Patrick and Alice Hayes
'Teach Tobar', Knockduff, Dunmanway, Co. Cork, P47 PX73

An Coimisiún Pleanála
64 Marlborough Street
Dublin 1, D01 V902
By email: appeals@pleanala.ie

17 September 2026

Re: ACP-324277-26 (SU04.324277) — substitute consent
ACP-324278-26 (FD04.324278) — section 37L
Murray Brothers Tarmacadam Ltd, Ardcahan, Dunmanway, Co. Cork
Section 131 submission: notices of 27 and 28 August 2026

- Ownership Area: 25 Ha
- Substitute Consent Application Area: 19.1 Ha
- Extraction Area (1990 - 2014): 5.2Ha
- Area not included in the Substitute Consent Area: 5.9Ha
- Ponds

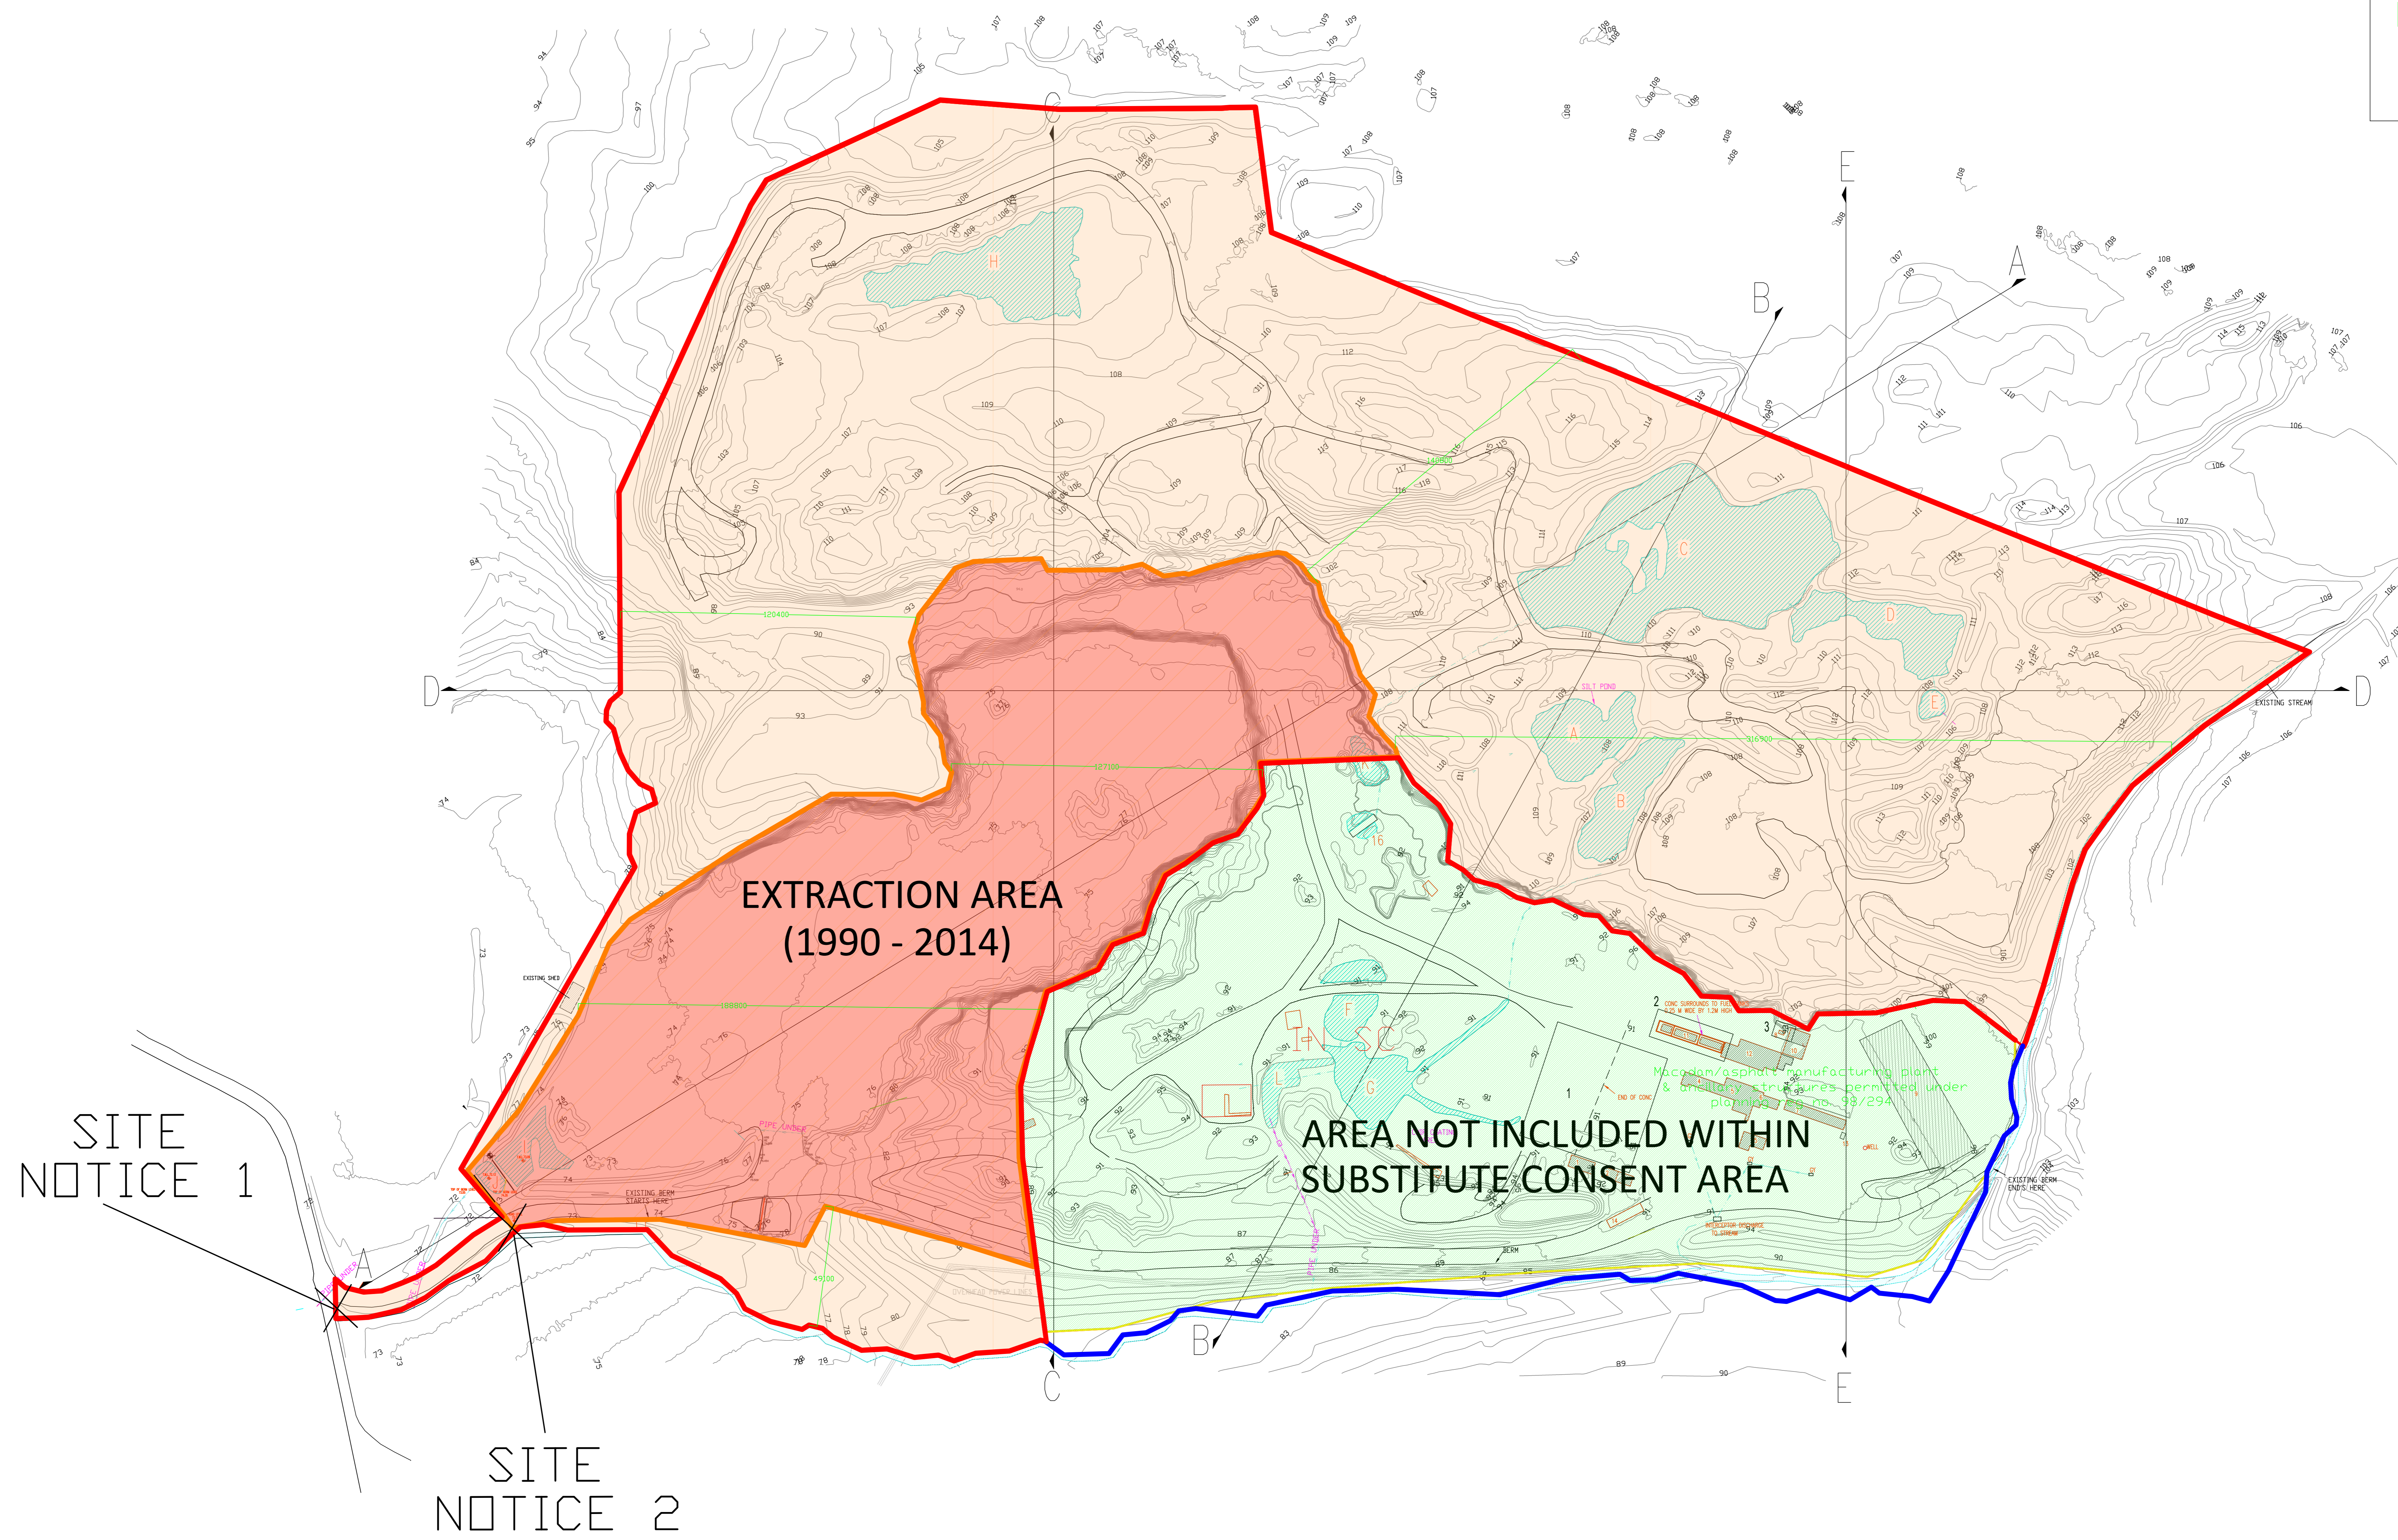
Matter	Applicant's response (14 Aug 2026)	Application documents
Substitute consent area	15.2 ha (Viridus)	19.1 ha (rEIAR Ch. 1)
Extraction area 1990–2014	5.94 ha (Viridus)	5.2 ha (rEIAR Chs. 1 and 8)
Nearest dwellings	275–450 m (letter, p. 5)	170 m, 180 m, 233 m (CLV Table 1, same filing)

The Council's 2012 assessment (enclosed) records that the quarry extended by approximately 2.7 ha between 1995 and 2000 and 2.0 ha between 2000 and 2005, with further expansion visible from 2010, and measured the total site area at about 8.1 ha on the 2005 aerial photograph. The Viridus letter gives a 1990 quarry area of 4.72 ha and a total extraction area for 1990 to 2014 of 5.94 ha, a difference of about 1.2 ha across the whole period.
